Recommendation Report for Planning Permission for Works or Extension to a Dwelling

REF NO: AW/46/21/HH

LOCATION: 15 Southwark Walk
Aldwick
PO21 3RR

PROPOSAL: Double storey side extension.

Proposed elevations and floorplans

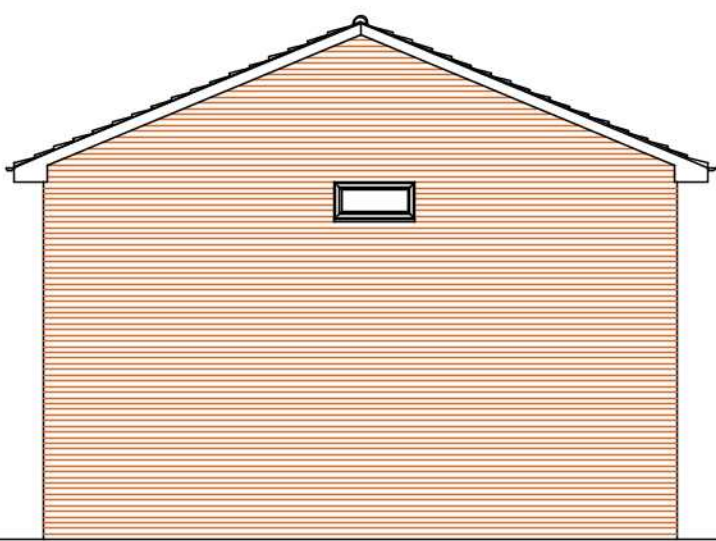
The proposal seeks to construct a two storey extension to the side of the dwelling and as such the works are visible from the street scene.

The proposal will have an unusual shape with a side wall angle. Whilst this would be a new feature to the locality it is not considered to cause detriment to the application as views would be limited due to the location of the proposal.

The neighbouring properties are similar in appearance however the addition is considered well integrated and with the use of matching materials is not considered to result in the dwelling appearing out of character with the area. Whilst the extension would close the gap between properties at the end of the terraces and lead to a further terracing impact it is not believed that the street is character of the road is characterised by relatively small gaps between the end terraces.

There will be additional windows and doors to the eastern elevation at the ground and first floor, due to the location with views over the front garden of the host and neighbouring properties, it is not considered to provide unacceptable overlooking. On the northern elevation there is to be one proposed window to serve the ensuite. To avoid potential overlooking this will be conditioned to be obscure glazed and not opening to 1.7m from ground height.

- 3 The window to the northern elevations of the building at first floor level shall at all times be glazed with obscured glass and fixed to be permanently non-opening below 1.7m internal floor level.

Proposed ground floor plan

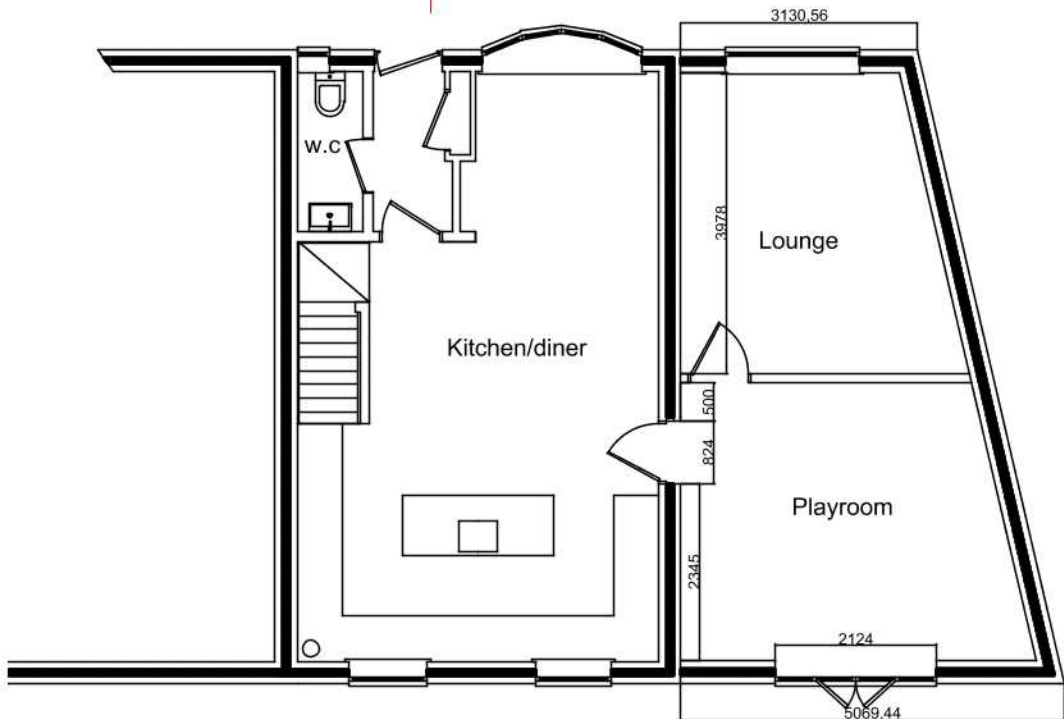
The side extension is situated to the northern elevation and will have a width of 3.13m at the ground floor on the principle elevation which will run along to the boundary. To the rear the extension is proposed to be a 5.096m in width retaining 10.2m to the rear boundary of the property, this is considered to be ample space to avoid overlooking the neighbouring properties.
